City of Mercer Island
Department of Community Development
Building and Land Use Planning Review

RE: Permit # 2203-002 - owner driven revisions
For proposed development at 4045 W Mercer Way
Parcel #: 362350-0395

This letter is to provide a brief synopsis of the property-owner driven changes to the building permit submission #2203-002 at 4045 W Mercer Way as instructed by Gareth Reece. The changes include the following:

**A2.3**

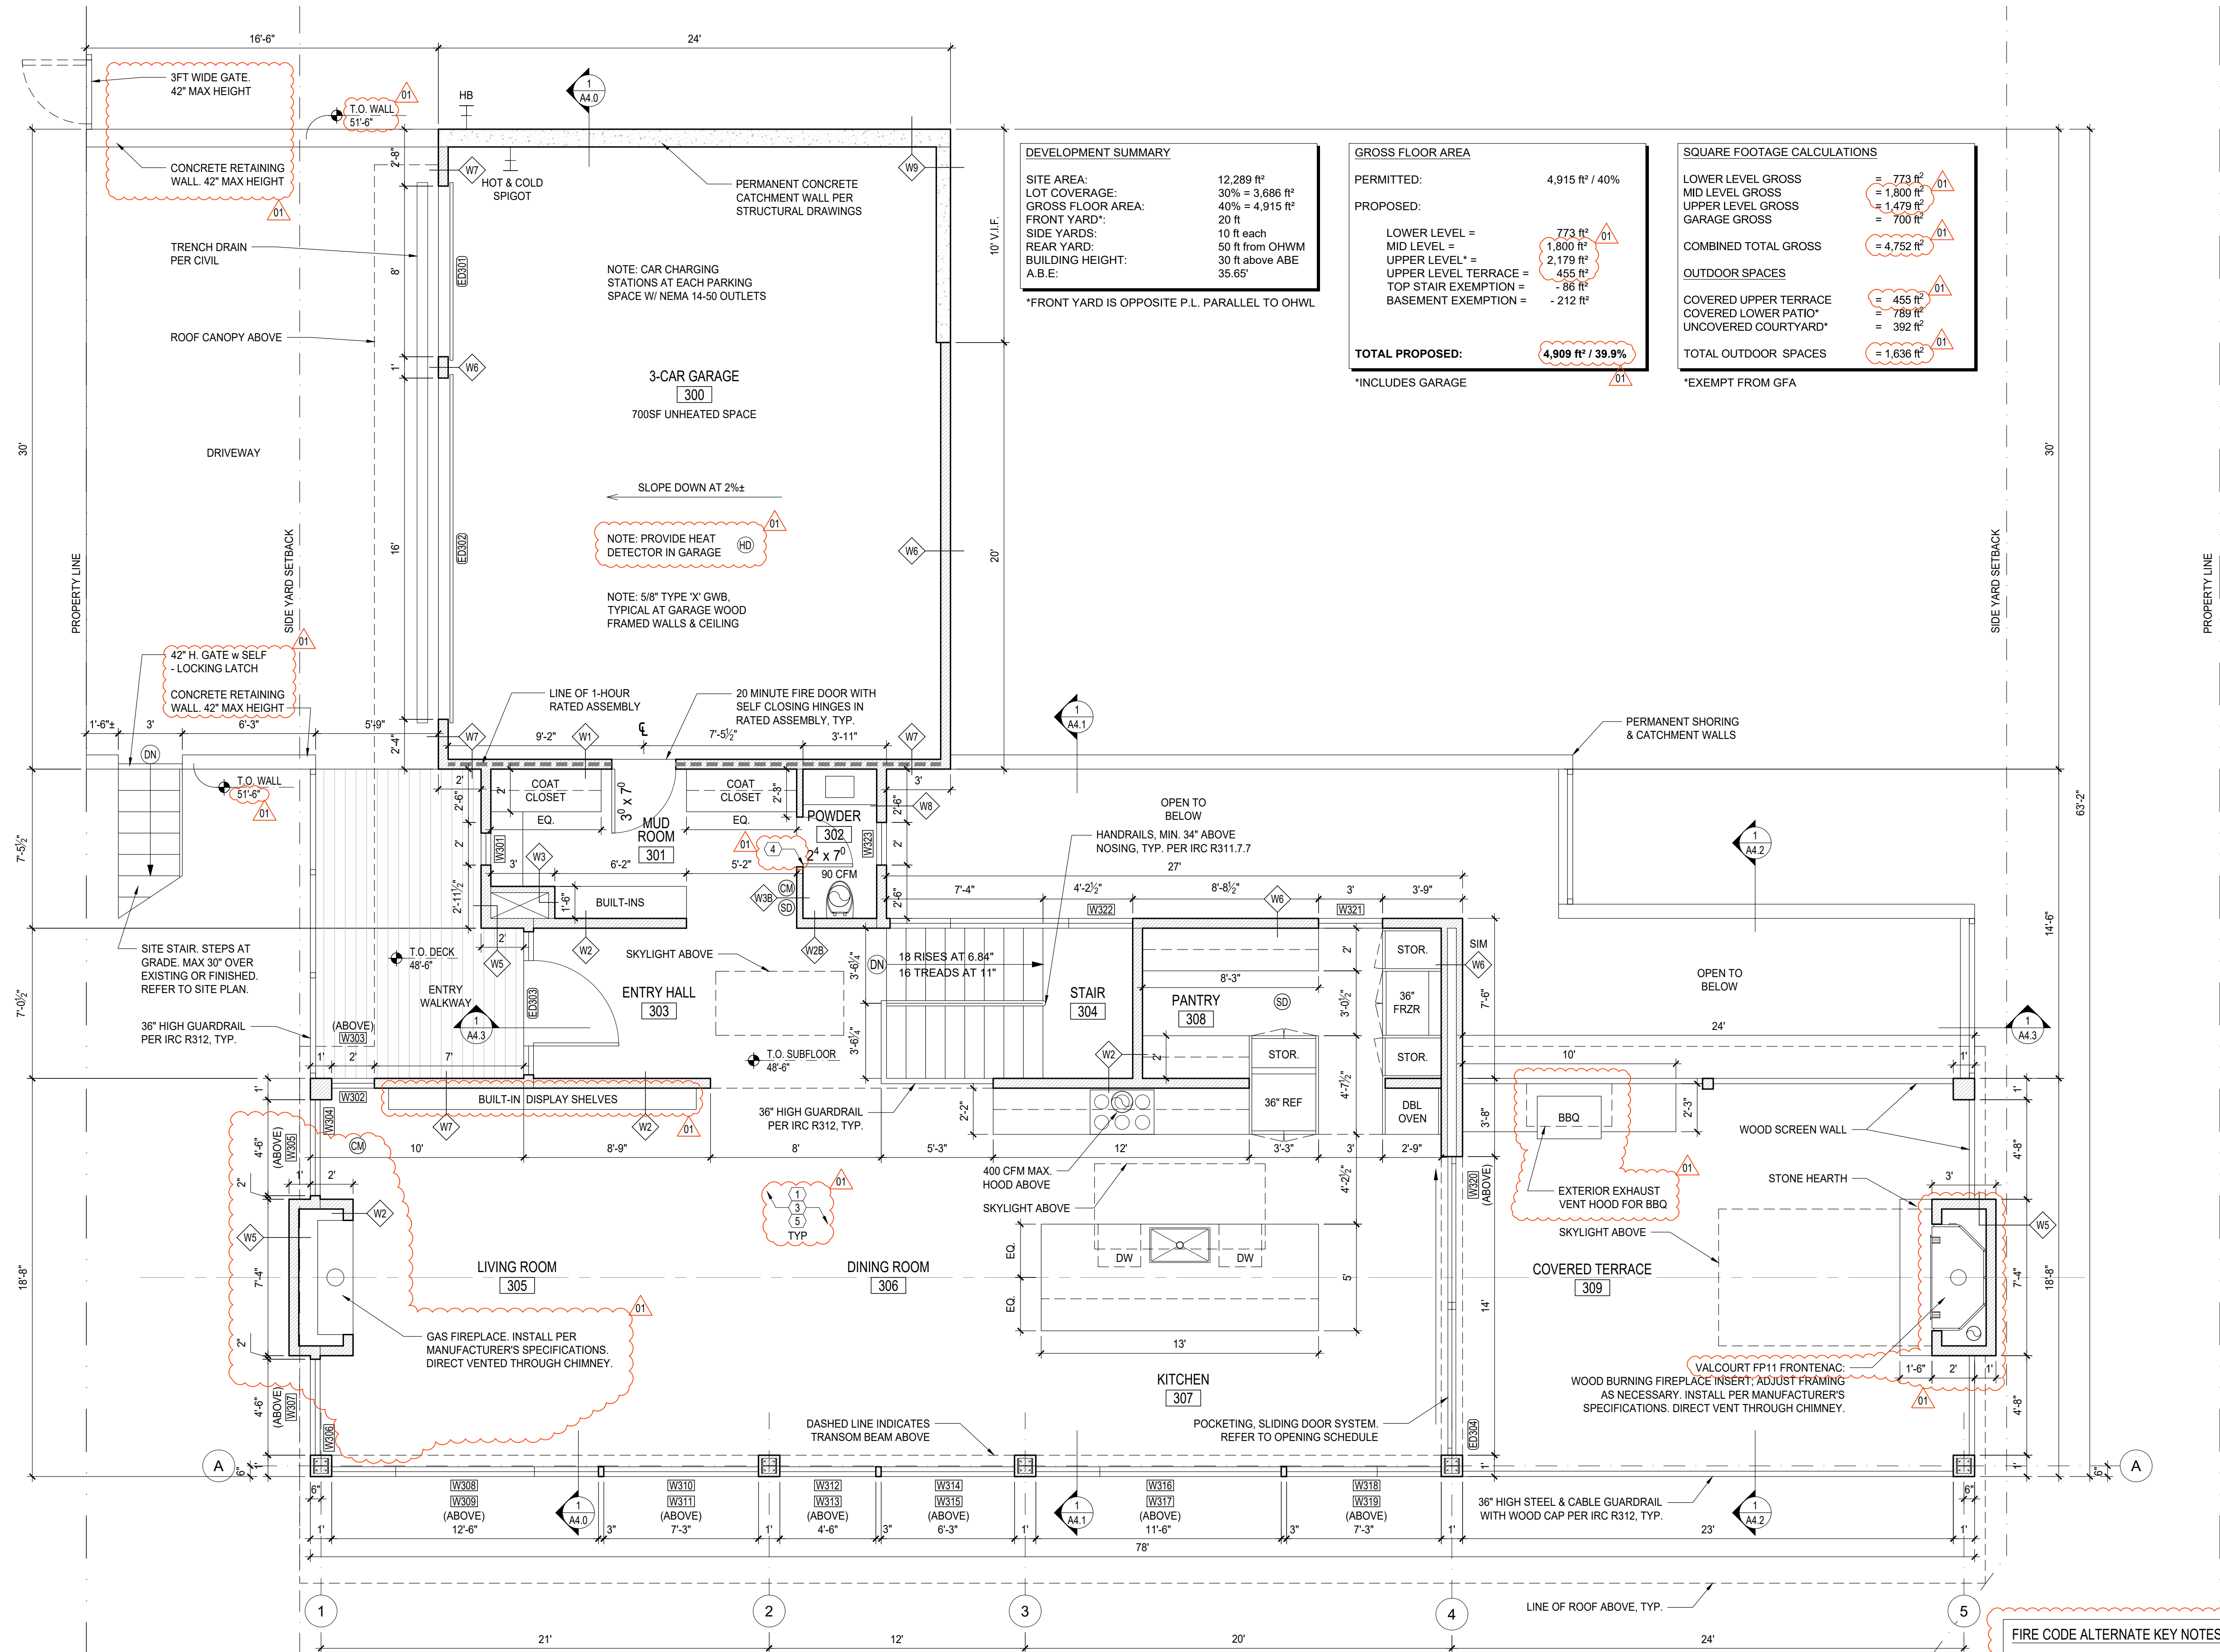
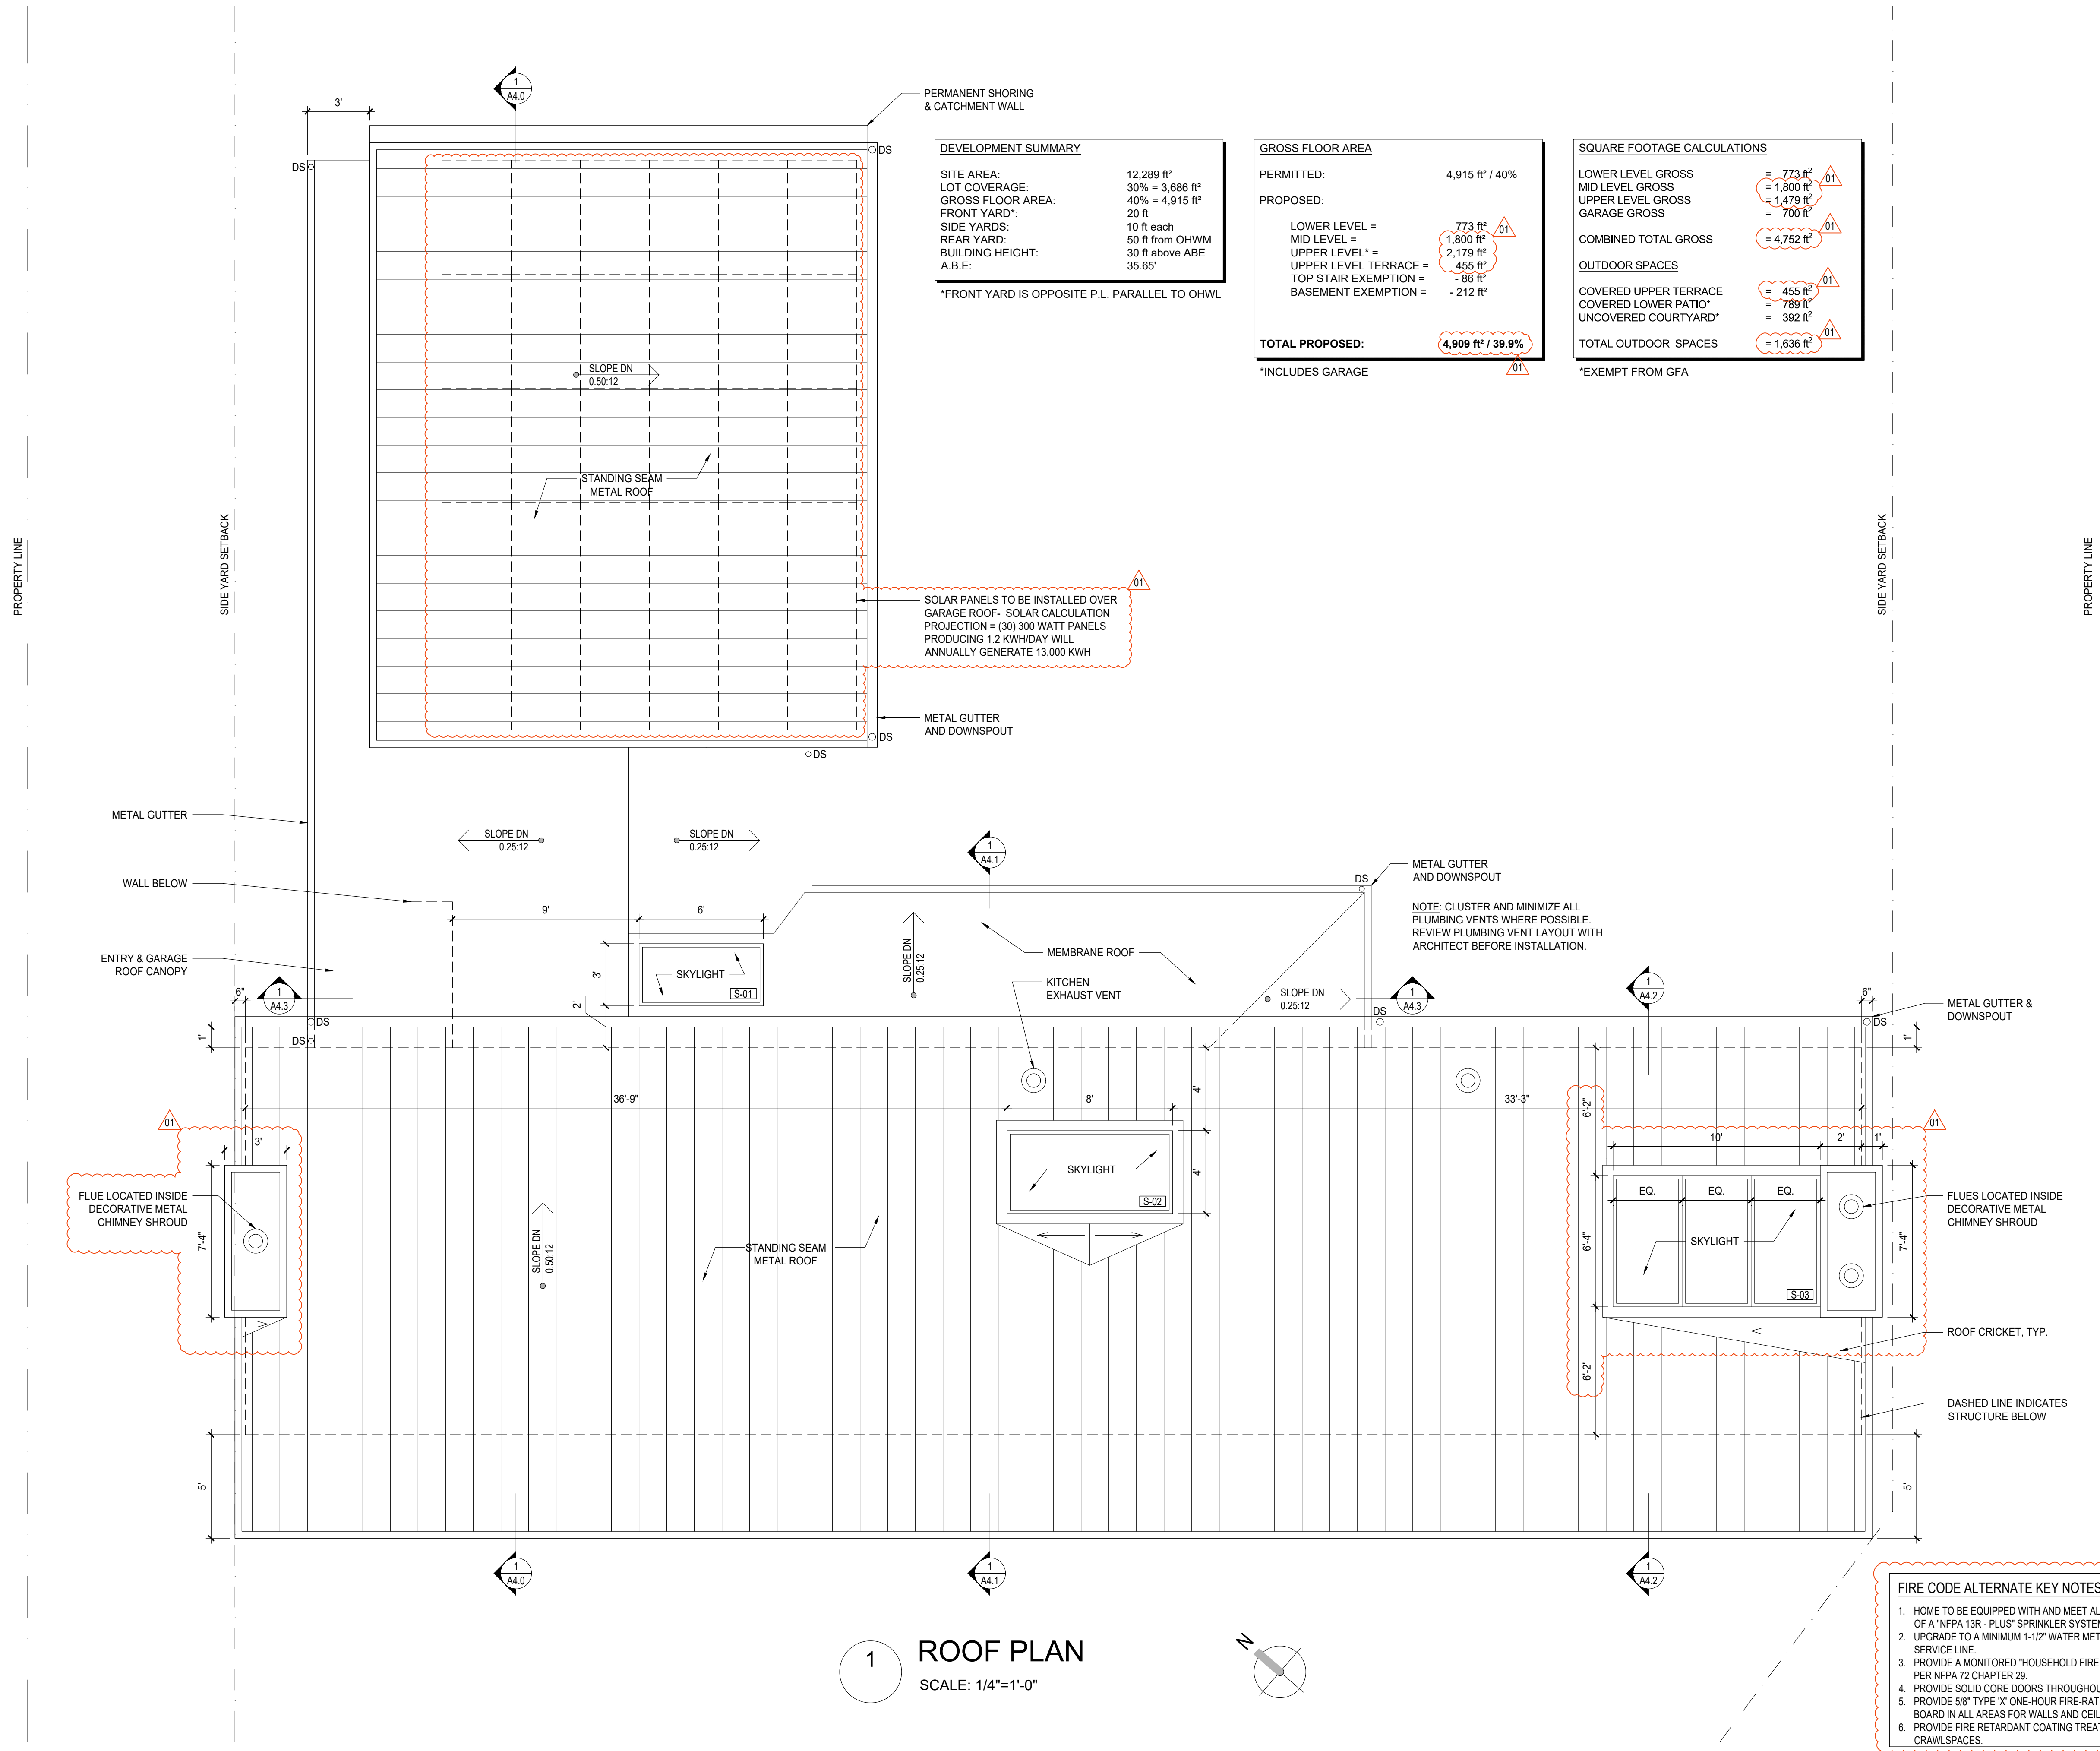
- 1) Revised fireplace location at the north end of the Living Room on the Upper Level Plan.
 - a) A traditional, gas fireplace with a chimney is proposed.
 - b) The plans, elevations and building sections have been updated and clouded.
 - c) The zoning code calculations for lot coverage and gross floor area have been updated and clouded.
- 2) A few windows have revised opening sizes or revised operability on the back side of the home.
 - a) The exterior elevations and opening schedule have been updated and clouded
